DECISION NOTICE

Application Ref: LU/365/14/PL

18 Norfolk Road
 Littlehampton
 BN17 5PN

First floor rear extension to create 1 No 1 bedroom first floor flat & new entrance porch (resubmission following LU/226/13/). This application affects the character & appearance of the Littlehampton Seafront Conservation Area.

DRAWING SCALE: 1:100 @ A1
Plans & Elevations
DATE: March 2013
DRAWN: A. H. Sutcliff
DRAWING: 1398/01 REVISION: F

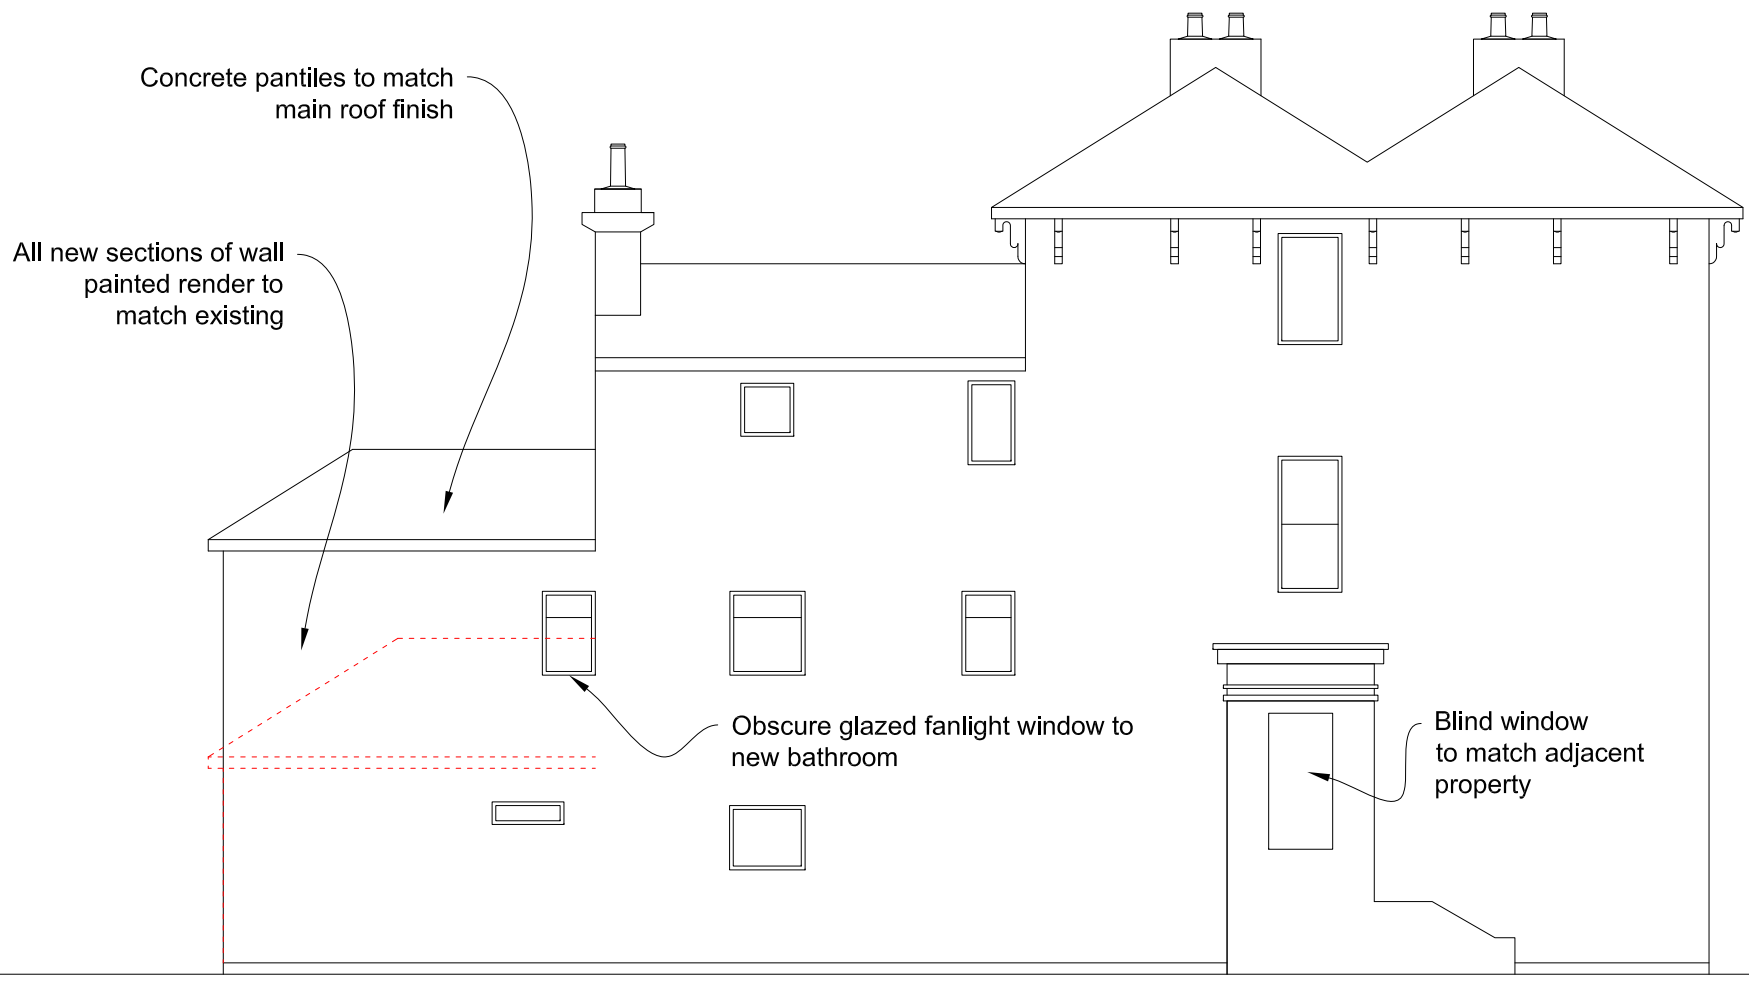
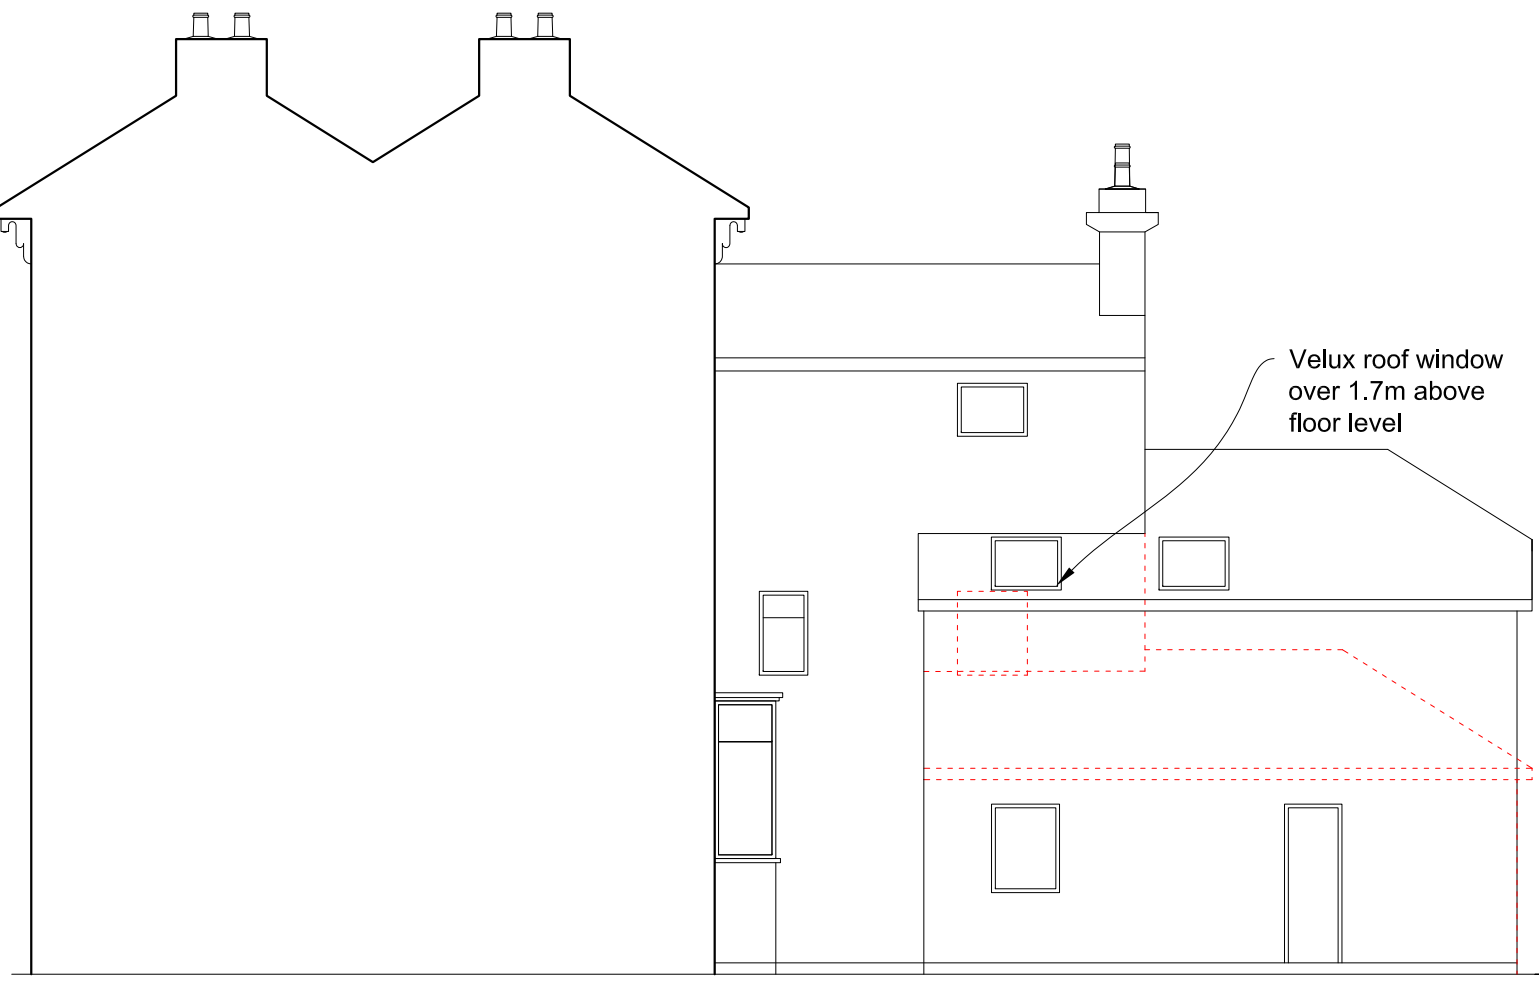
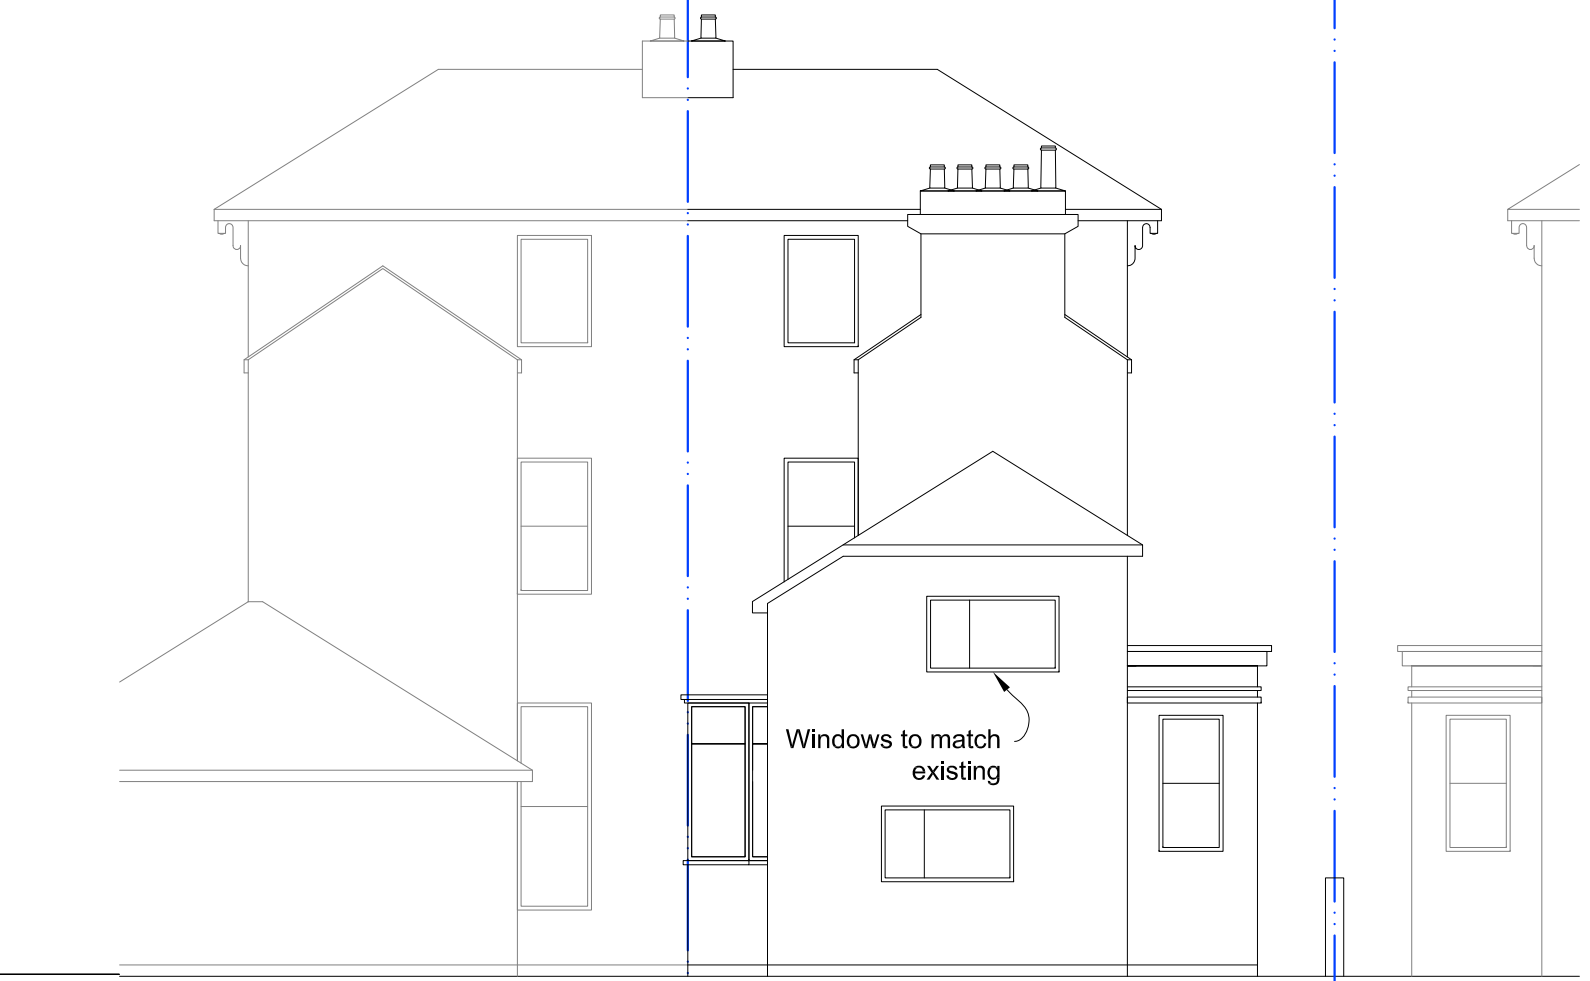
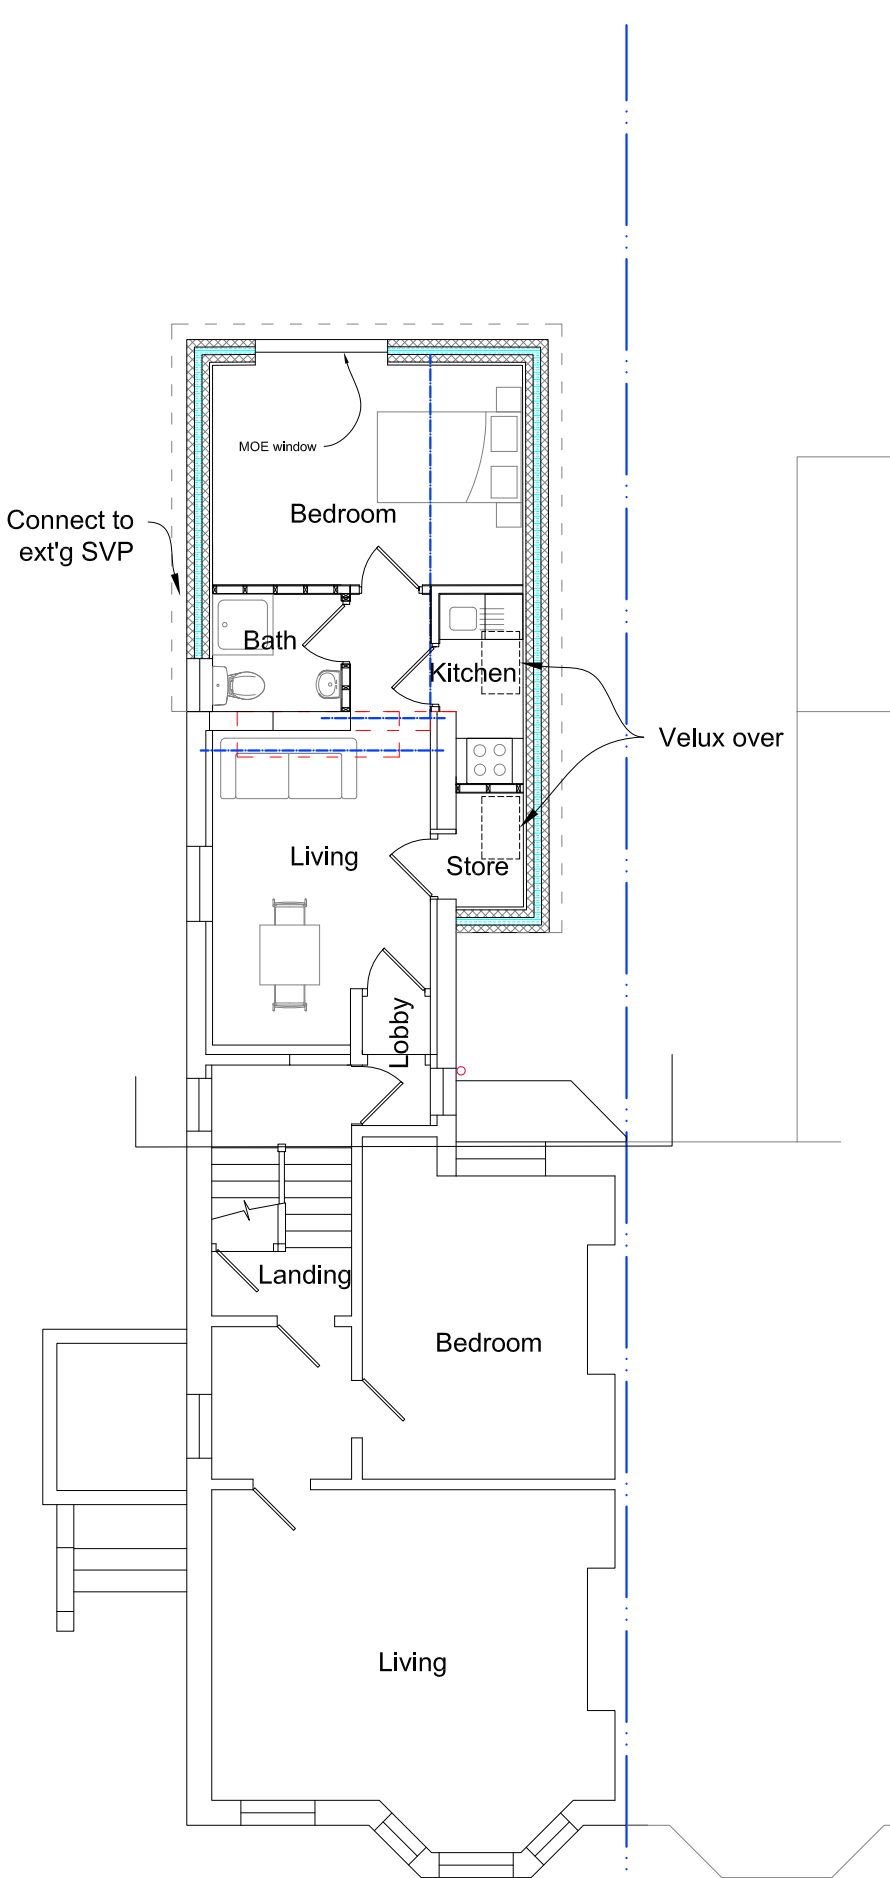
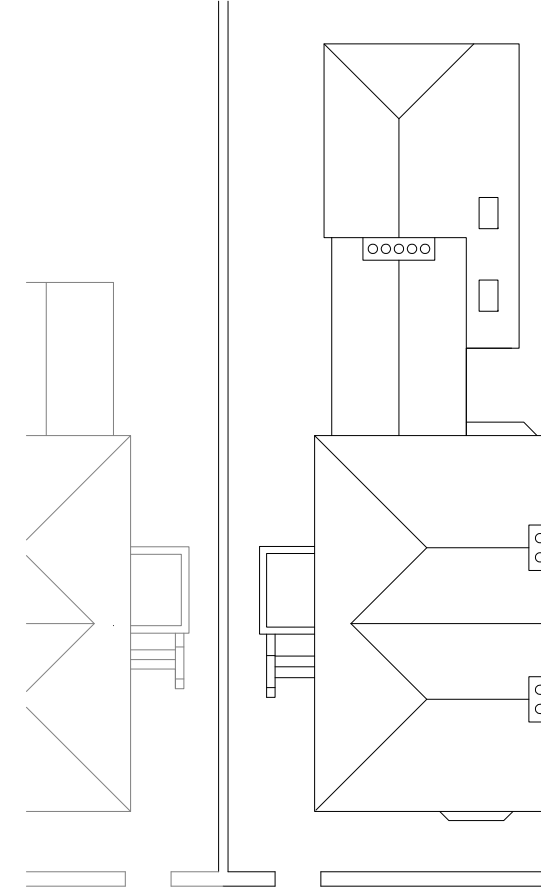
1 The site is within an area designated as a Conservation Area under Section 69, 70 and 72 of the Planning (Listed Buildings and Conservation Areas) Act 1990 and the building is defined as a Building of Special Character on the Local List and the proposal by reason of its width, depth, design and height would conflict with the Local Planning Authority's intention to protect and enhance the visual amenities and environment of such areas and the appearance of the existing building and with policies GEN7, GEN22 and AREA2 of the Arun District Local Plan and policies DSP1, DDM1 and HERDM3 of the Emerging Local Plan.

- 3 By reason of its height and proximity to the boundary the proposal would result in an unneighbourly form of development which would be detrimental to the residential amenities of the adjoining property to the north, contrary to policies GEN7 and DEV19 of the Arun District Local Plan and policies EDDM4 of the Emerging Local Plan.

2 The proposed residential accommodation would not meet the adopted internal and external space standards of the emerging local plan. It would therefore be detrimental to the residential amenities of the existing property and the future occupiers in conflict with policy GEN7 of the Arun District Local Plan and policies DDM2 and DDM3 of the Emerging Local Plan.
